Curl Curl North Public School Redevelopment, Playfair Road, North Curl Curl (SSD 8310)

Notice of Exhibition

TAB A – Comments on State Significant Development Application

Proposed Signs and Lines Plans as at September 2018

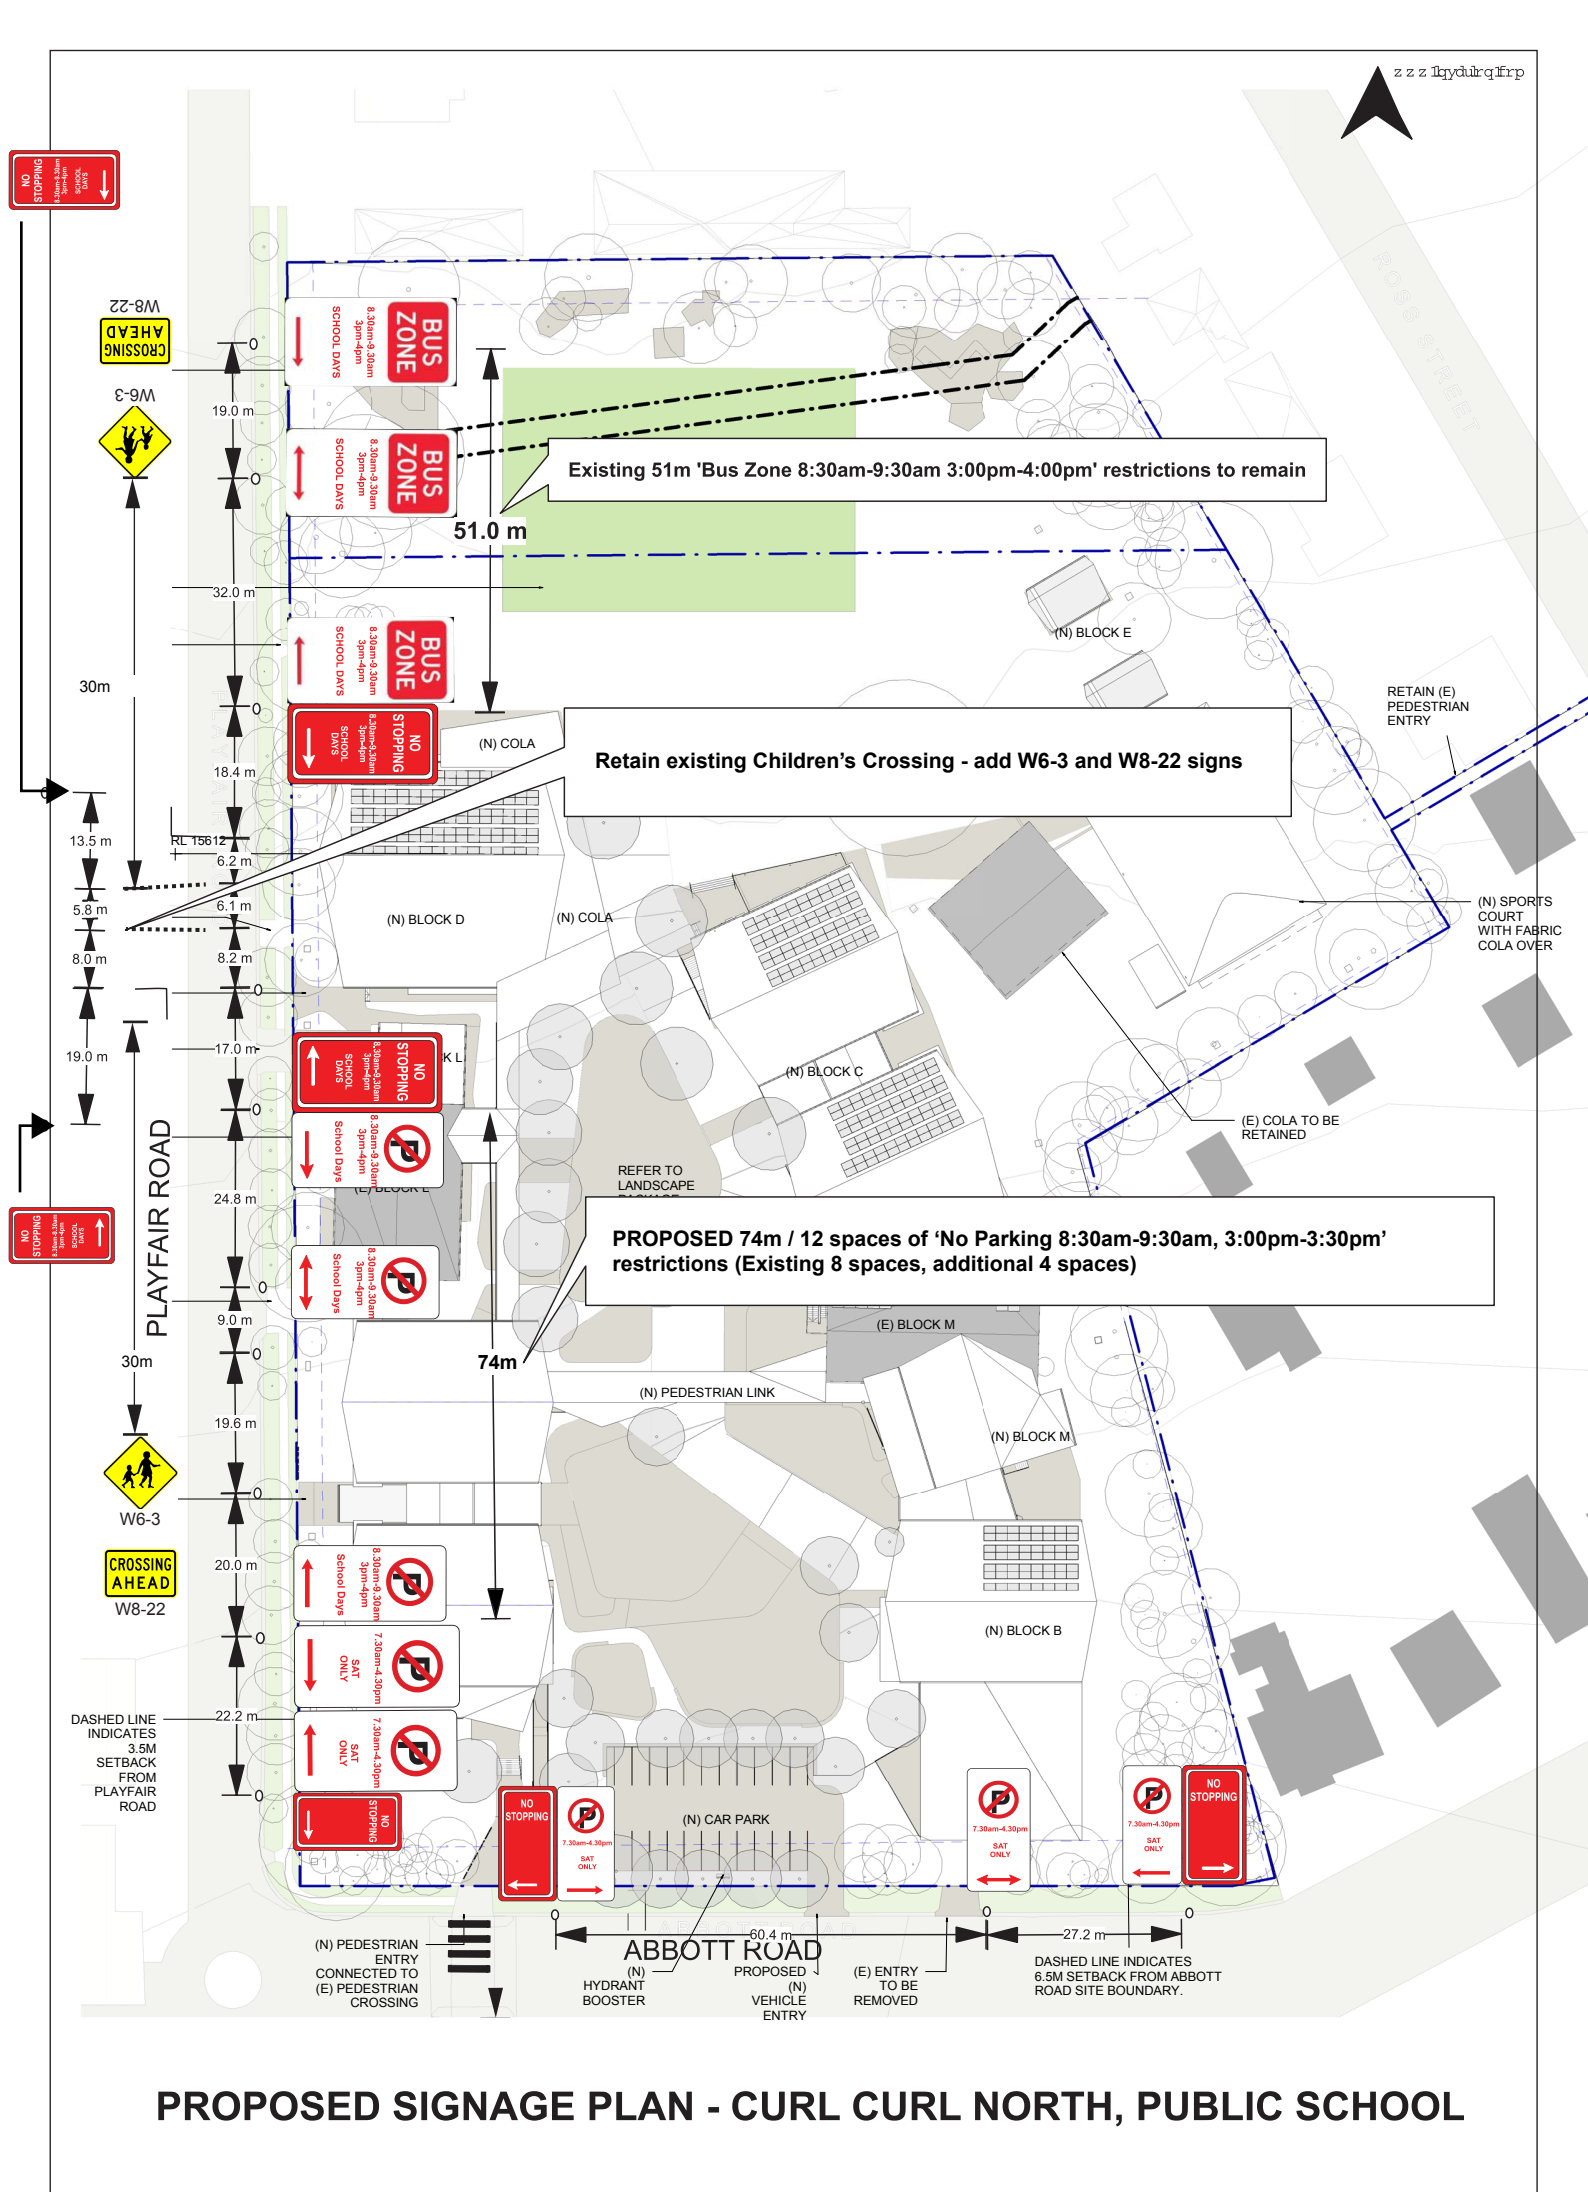
The proposal to remove the children's crossing along Playfair Road would need to be considered by Northern Beaches Council and Roads and Maritime. It is anticipated that any removal of the crossing would require a road safety assessment.

The redevelopment of the school would result in the alteration of the primary pedestrian access point from Playfair Road to Abbott Road in conjunction with the change in the primary street frontage from Playfair Road to Abbott Road. Furthermore, staff car parking access would also change from Playfair Road to Abbott Road. Based on the provision of 17 staff parking spaces and demand for 70 parking spaces (76 staff with 93% vehicle driver mode share), it is likely that "spillover" staff parking would also impact Abbott Road.

In this regard, this could result in a change in the desired pick-up and drop-off location along Playfair Road (near the existing children's crossing) closer to the primary access point on Abbott Road. The change in desired pick-up/drop-off location would also be encouraged by the proposed removal of the children's crossing.

TfNSW advises that the proponent should consider relocating existing or implement additional pick-up/drop-off zones given the likely change in the desired pick-up/drop-off locations closer to the designated main pedestrian access and competing demands generated by staff parking along Abbott Road.

Furthermore, the existing bus zone should be relocated closer to the school frontage, southwards along Playfair Road in proximity to the secondary pedestrian entry (adjacent to the library).
